CARRAIGIN POWER LTD

CARRIGEEN RENEWABLE ENERGY DEVELOPMENT, CO. ROSCOMMON

RESPONSE TO SUBMISSIONS

**PLANNING APPLICATION CASE REFERENCE:
PAX20-324167**

Figure 4.2: Roscommon CDP Designates Areas for Wind Farm Development.

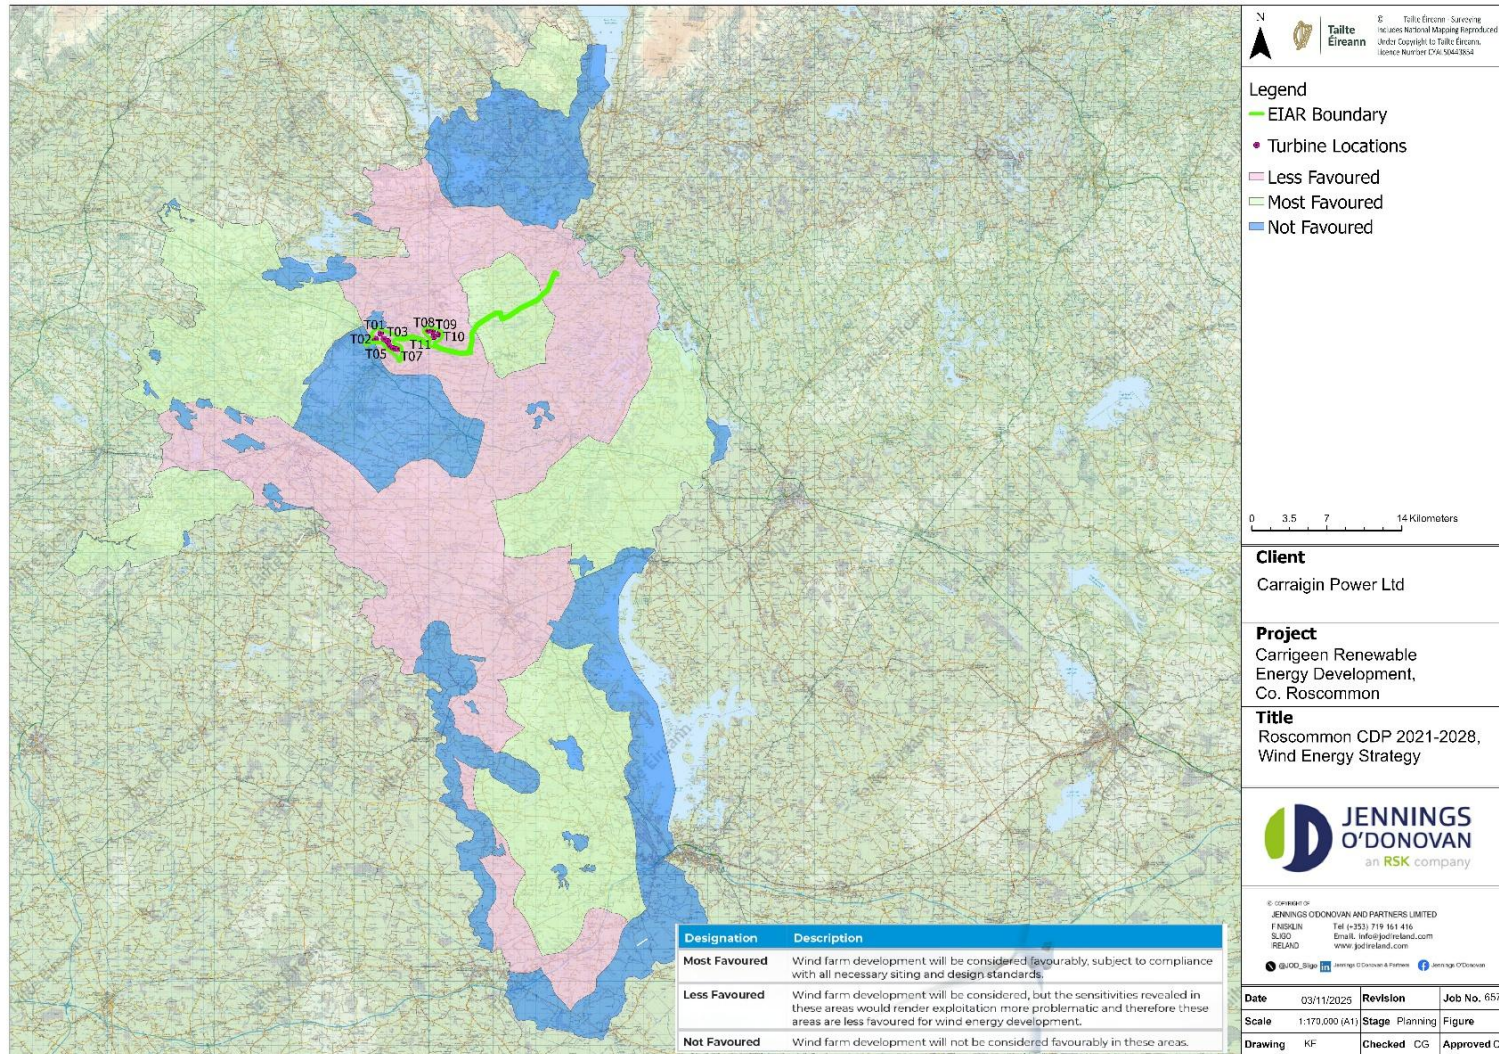
Point 3:

The Project falls within an area designated as 'Less Favoured' within the Roscommon County Development Plan 2022-2028. The rationale for this is discussed in **Section 4.1.1** below.
